Response to Fire & Rescue Consultation

Re: P/99/26/PL - Land north of Lagnersh House, Lower Bognor Road, Lagness, Chichester PO20 1LW

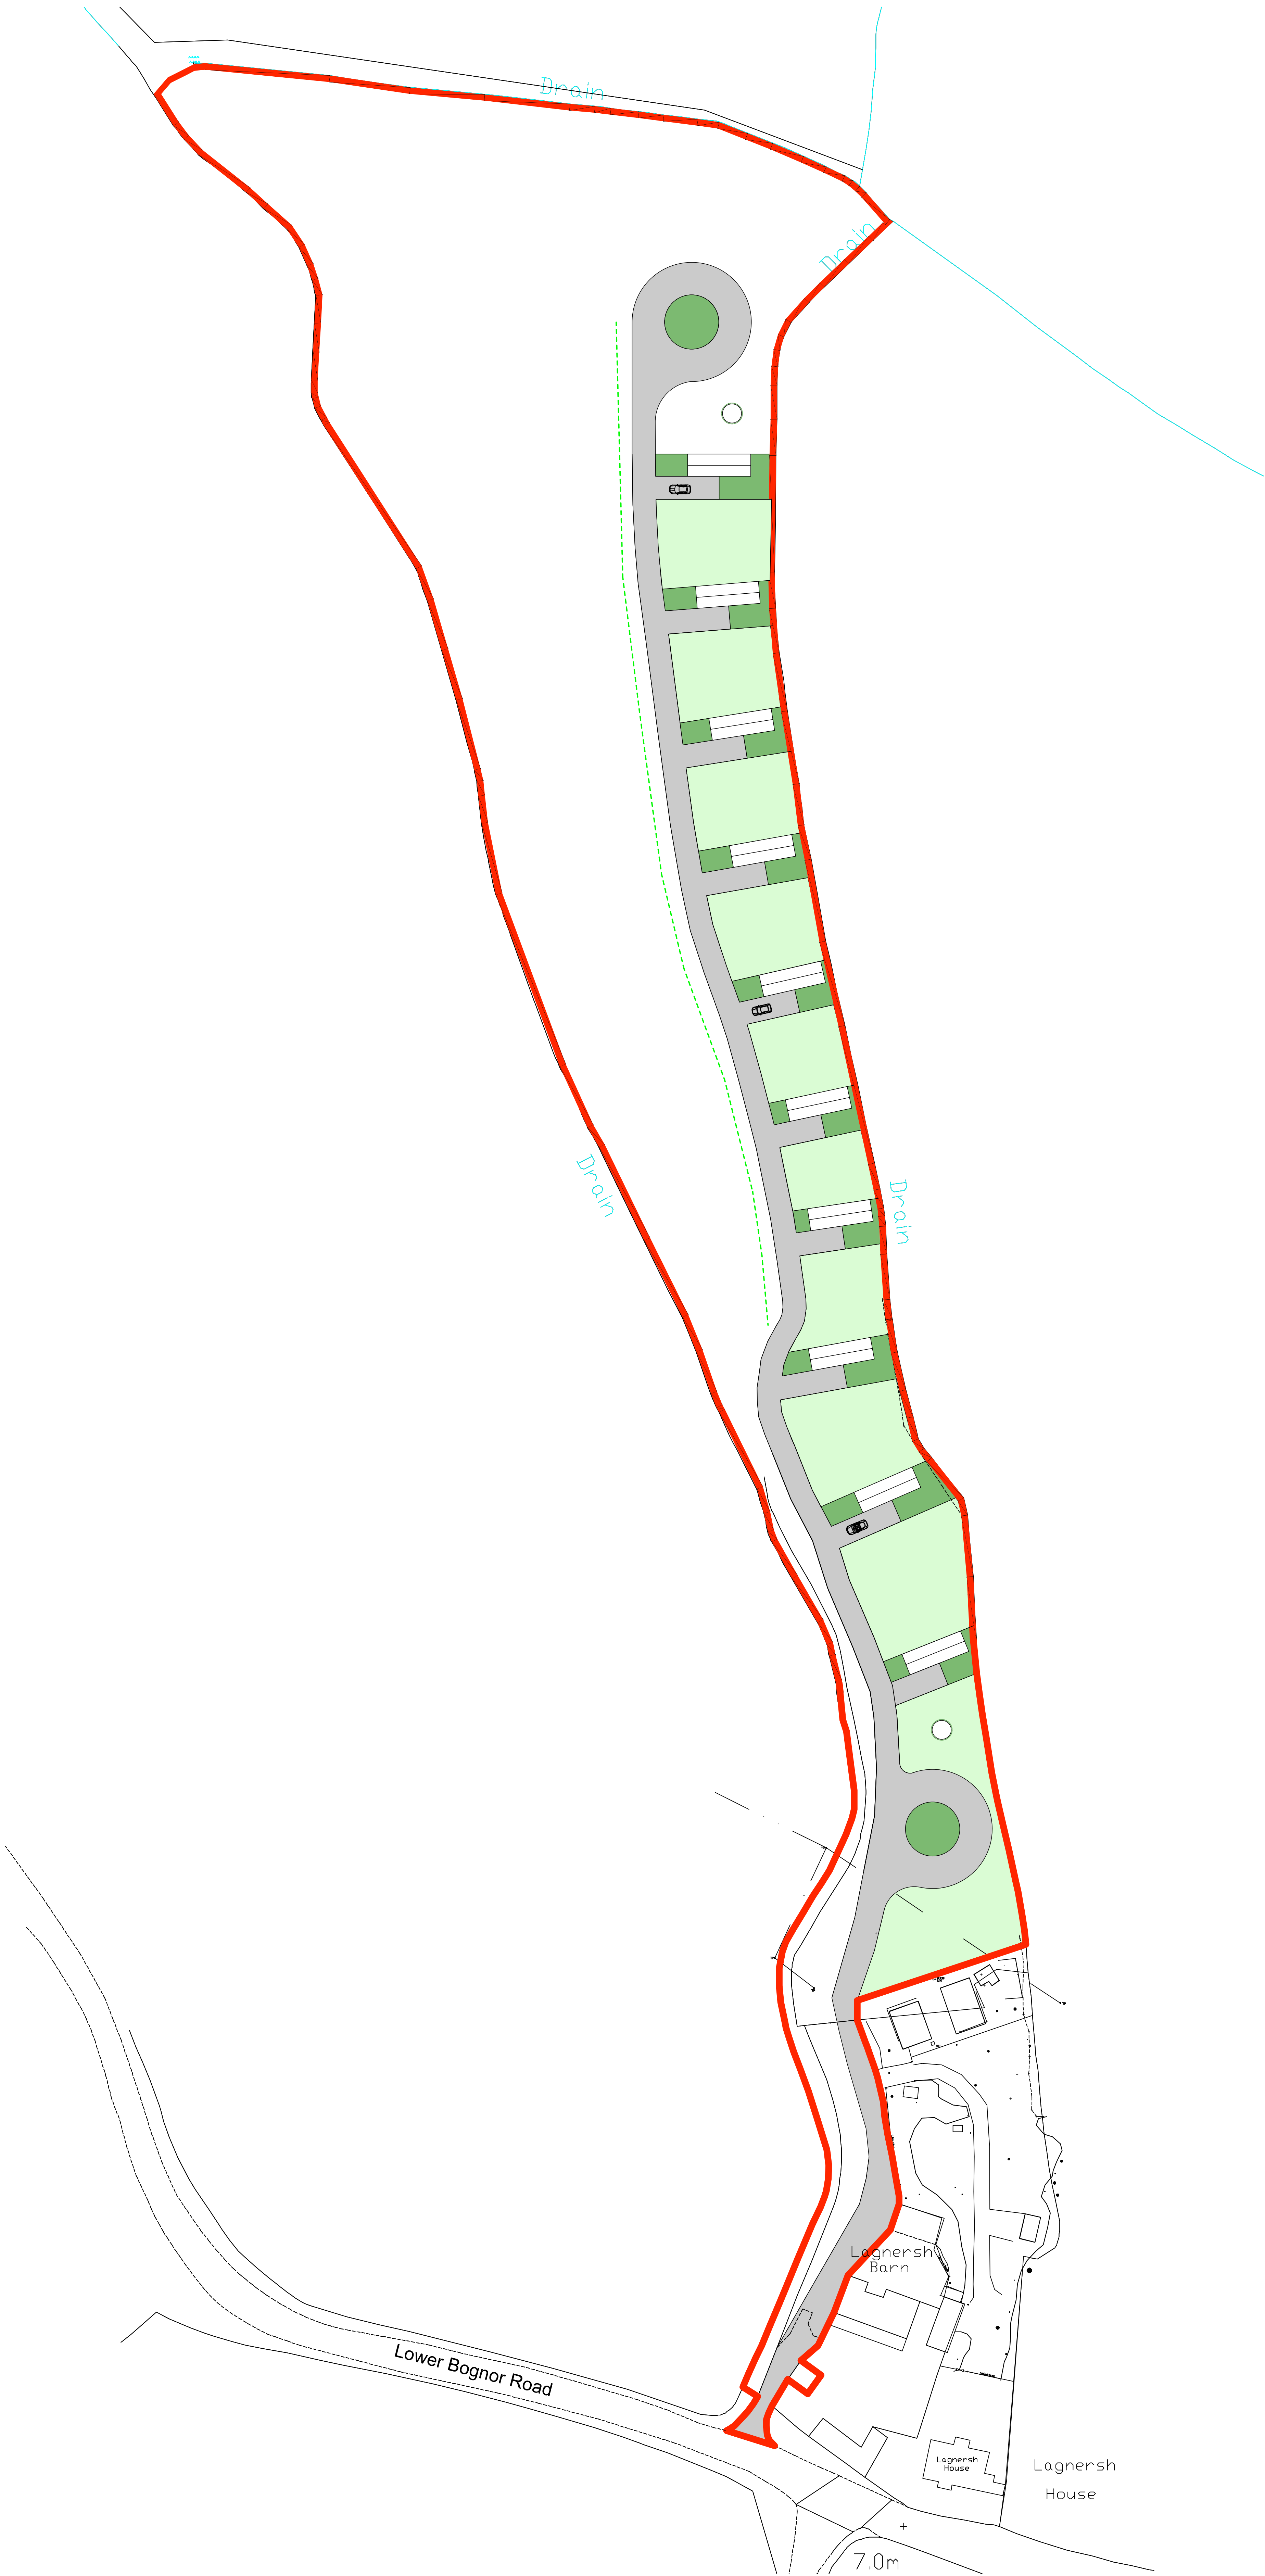
The main matters raised related to fire appliance access to the holiday lodges and the distance to an adequate firefighting water supply. We have therefore undertaken vehicle tracking and made changes to the layout specifically in response to these comments.

The revised layout and tracking have been prepared to demonstrate suitable access for a fire appliance to get within the required **45 metres** of all points within the proposed lodges. The access arrangements have also been considered having regard to the Fire & Rescue Service's comments concerning an appliance capable of supporting an **18-tonne axle weight**.

We have also addressed the concern that the original firefighting water tank was more than **150 metres** from the furthest holiday lodge.

Vehicle tracking has now been undertaken for a fire rescue appliance. The revised plan includes turning facilities at both ends of the lodge development, allowing a fire appliance to enter the site, travel along the internal access road and turn safely.

An additional **10,000-litre water storage tank** has now been added at the opposite end of the lodge development. The revised scheme therefore provides firefighting water storage at both ends of the site, giving much better coverage and ensuring that water is available within the required distance of the lodges.

Both tanks are shown on the revised drawing on concrete slabs and will be screened by conifer planting.
